**Subject:** Planning application 2023/91212: Land off Bankfield Drive, Holmbridge

PROJECT	CLIENT				
BANKFIELD DRIVE, HOLMBRIDGE	ORION HOMES				
DRAWING TITLE	CHECKED	APPROVED	DRG No.		
	PO	PO	22027/GA/01		
	DRAWN BY:	SCALE @ A2	DATE	REV.	
DOBB TOP ROAD/ BANKFIELD DRIVE PROPOSED IMPROVEMENTS	SG	1:200	NOVEMBER 2023	D

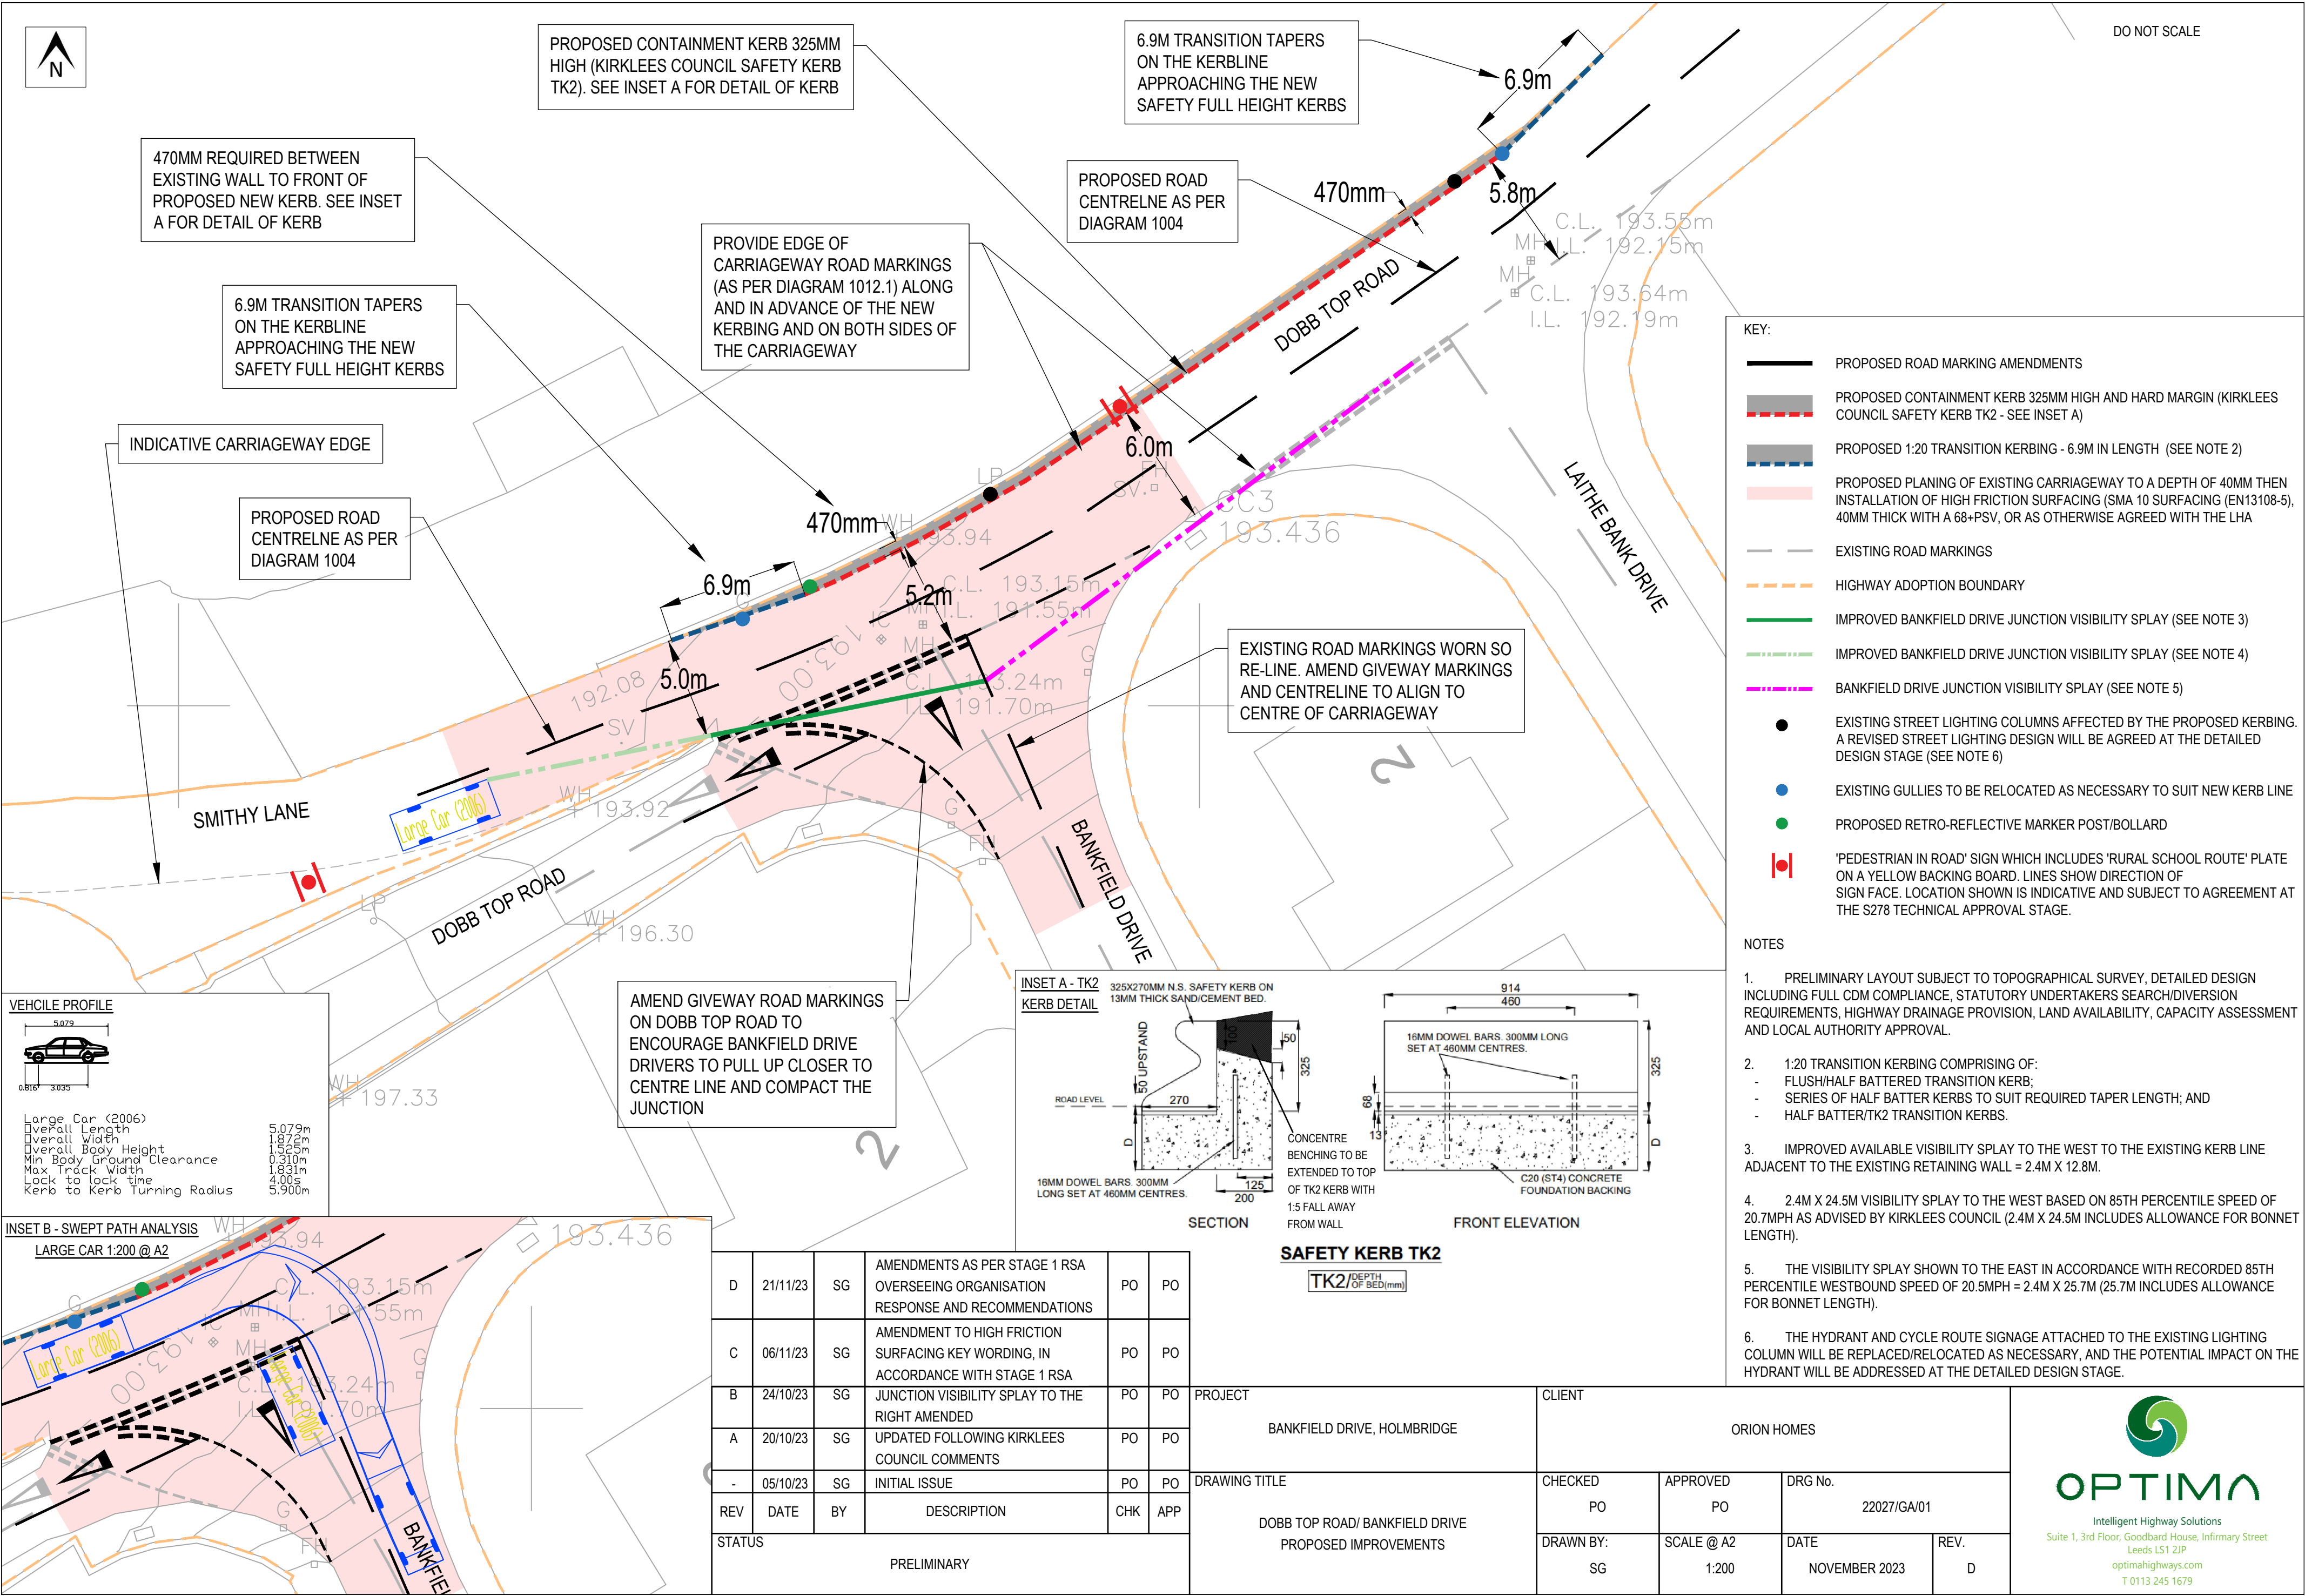
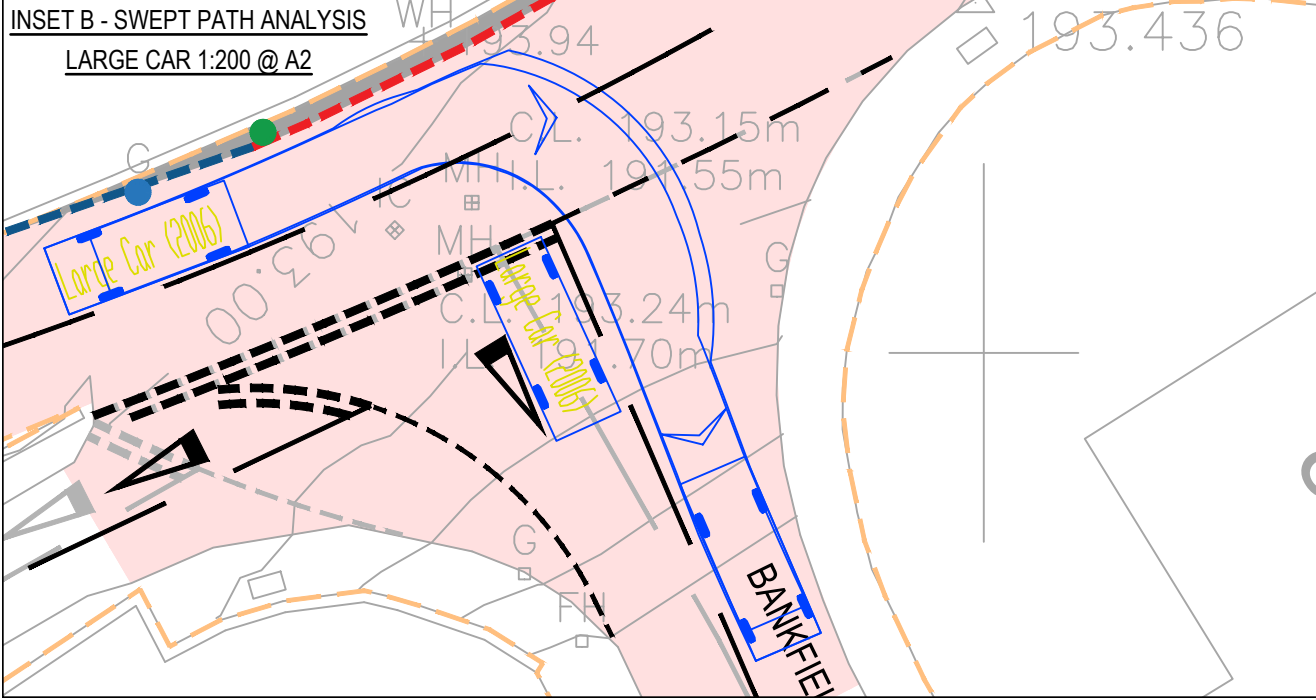
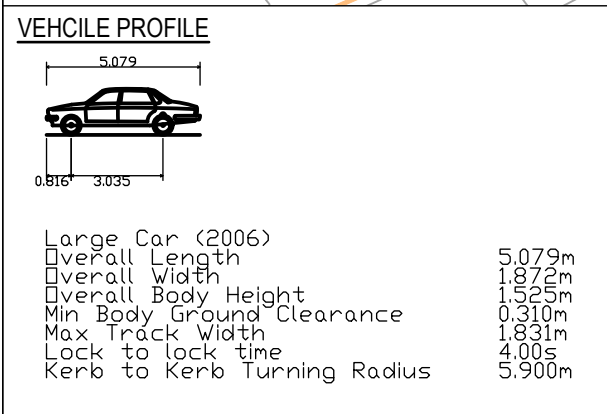
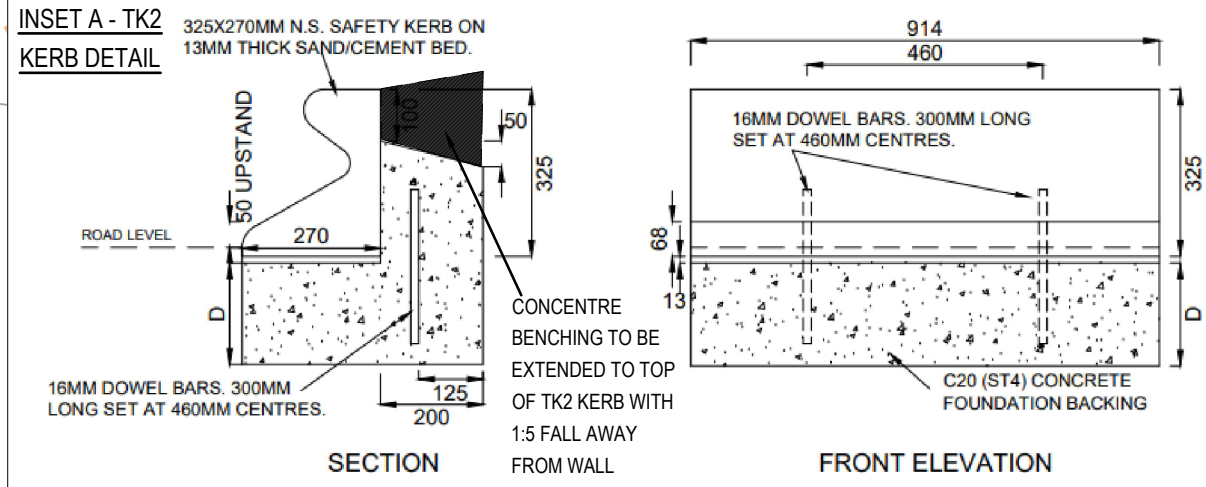
6. I refer to my email dated 29<sup>th</sup> November 2023. A number of our statements and questions with reference to incorrect information and figures contained within the Optima highways reports, along with our worries regarding pedestrian safety have not been adequately addressed by the most recent response from Kirklees Highways. Pedestrian safety has been largely ignored even though it is by far the most common reason that existing residents are objecting to the planning application. We live here. We see the incidents at the dangerous junction first hand. A safety kerb to help protect the wall from cars hitting it simply means that pedestrians (especially children) will have to walk further out into the already narrow road than they do now. It is common sense.
